re: Geotechnical Responses to City Comments
Proposed High-Rise Building
1040 Somerset Street West - Ottawa

date: March 28, 2022

file: PG2674-MEMO.14

A EAST ELEVATION
1:100

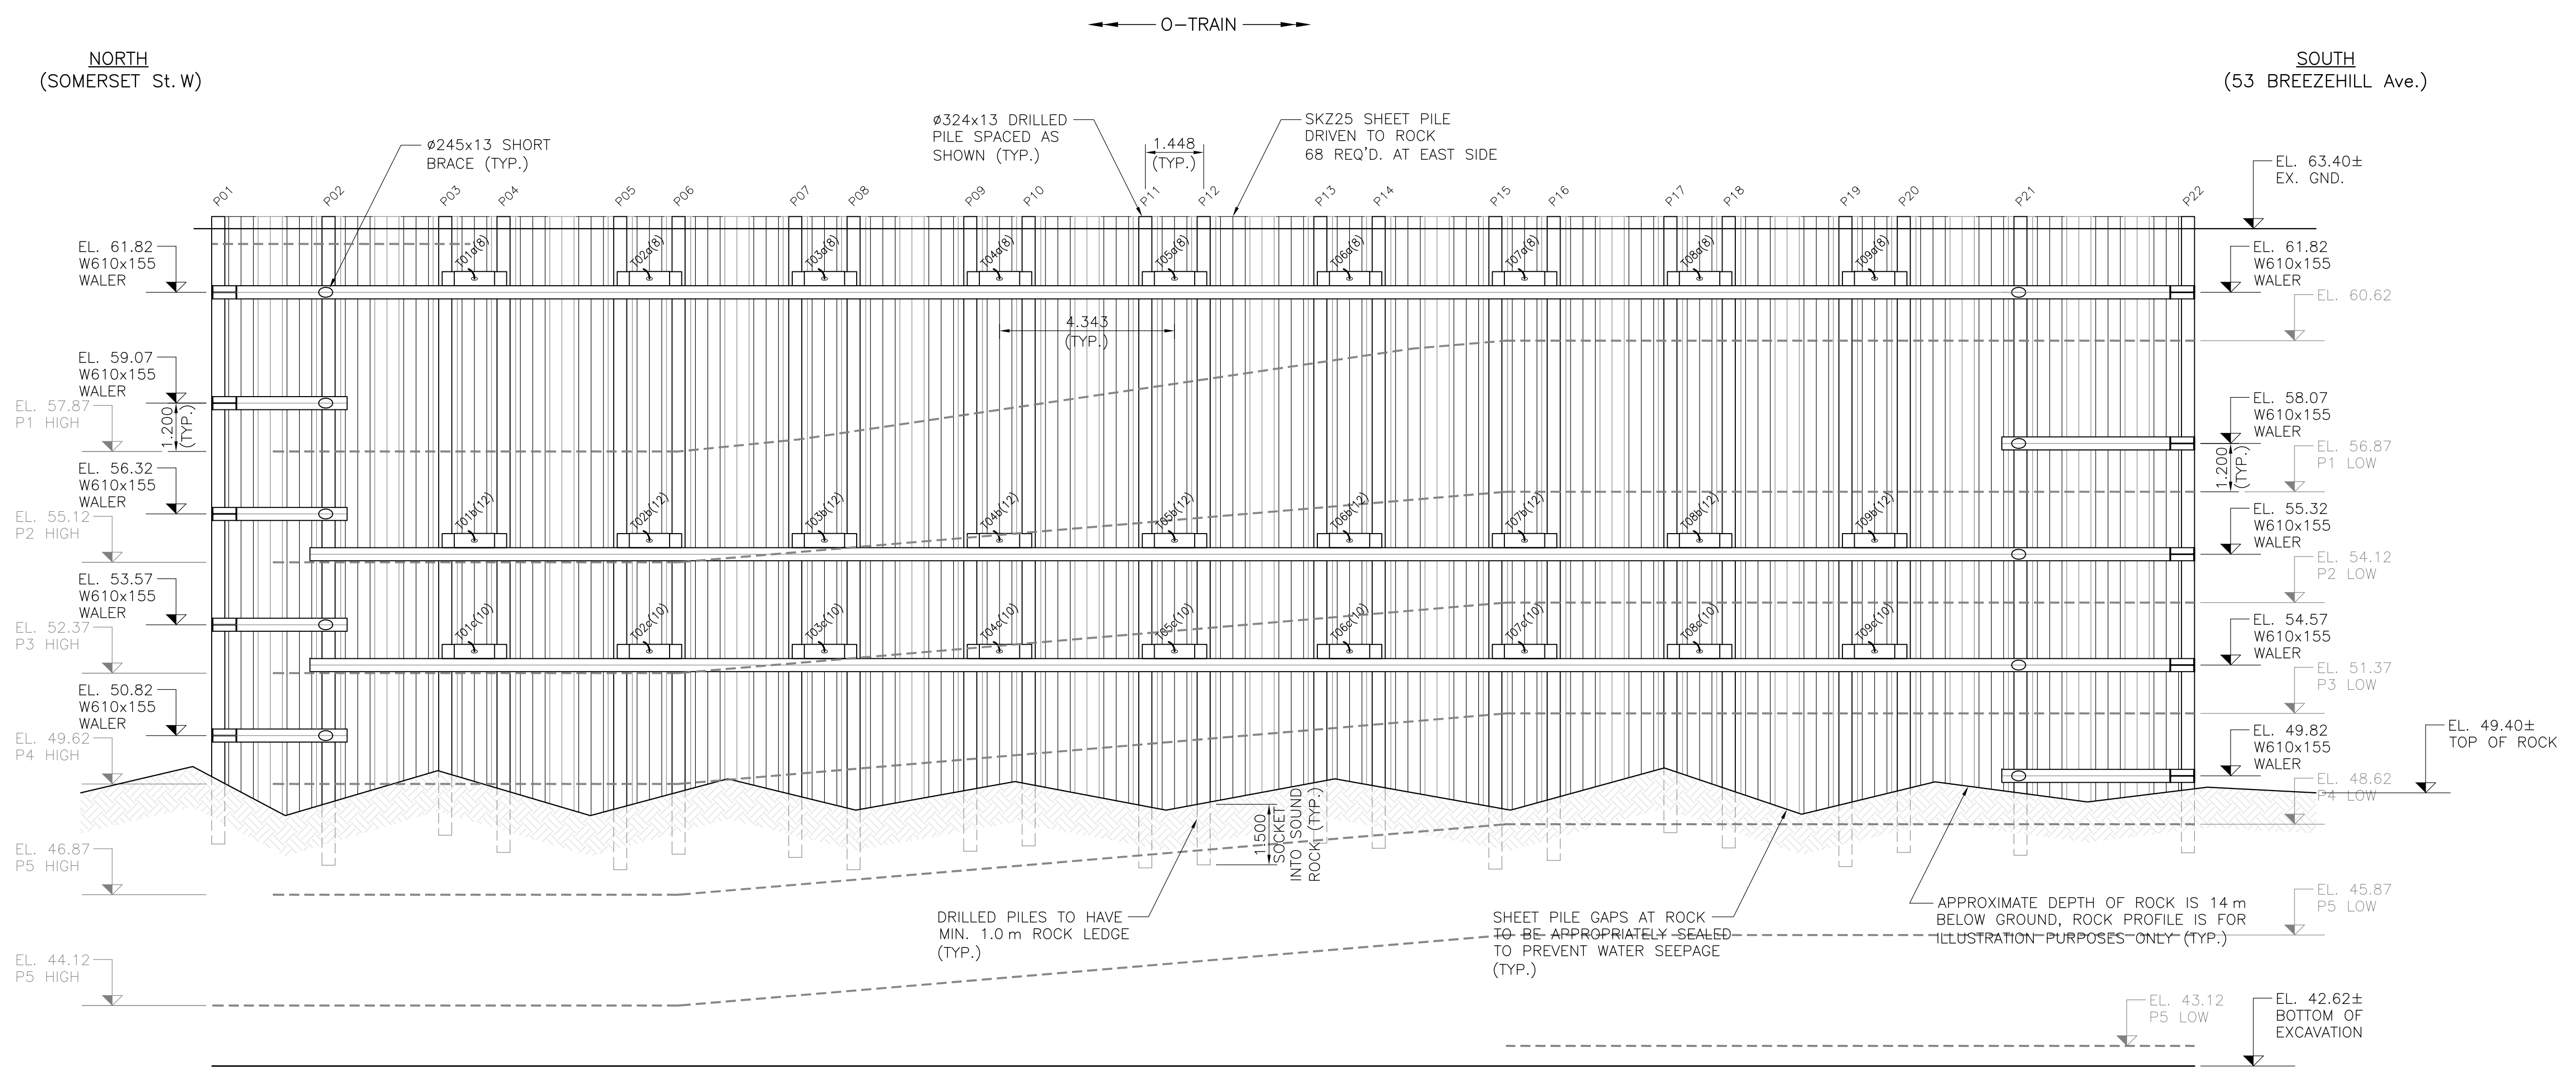
Comment: *What impact will short-term dewatering have on the proposed shoring system have on the existing bridge abutment and retaining wall structure.*

Response: Short-term dewatering of the underlying soils over a 12 month period for construction will not cause excessive settlement of the shallow footings supporting the retaining wall structure of the bridge overpass. Paterson has reviewed the soil conditions immediately below the existing retaining wall and the overall soil overburden profile as part of our geotechnical investigation.

Based on our observations, the soil below the retaining wall structure consists of a compact to dense, silty sand with gravel and cobbles, which was noted to be dry followed by a stiff to very stiff, silty clay deposit with low moisture levels. The abovenoted layers are underlain by a glacial till, consisting of a silty sand with clay, gravel, cobbles and boulders. The groundwater level was encountered within the glacial till layer, which is considered to be resistant to settlement due to short-term dewatering based on our observations and testing results.

It is understood that a temporary shoring system will be installed adjacent to the bridge abutment and retaining wall structure, which will allow dewatering of the supported soils. However, it is expected that the extent of dewatering will be limited due to the soil consistency. Also, the glacial till layer is not expected to undergo any significant settlement (ie.- less than 5 mm) due to the short-term dewatering. Therefore, the shallow footing supported retaining wall structure will not undergo excessive settlement (ie.- less than 5 mm) due to the short-term dewatering associated with the proposed excavation program for the subject site.
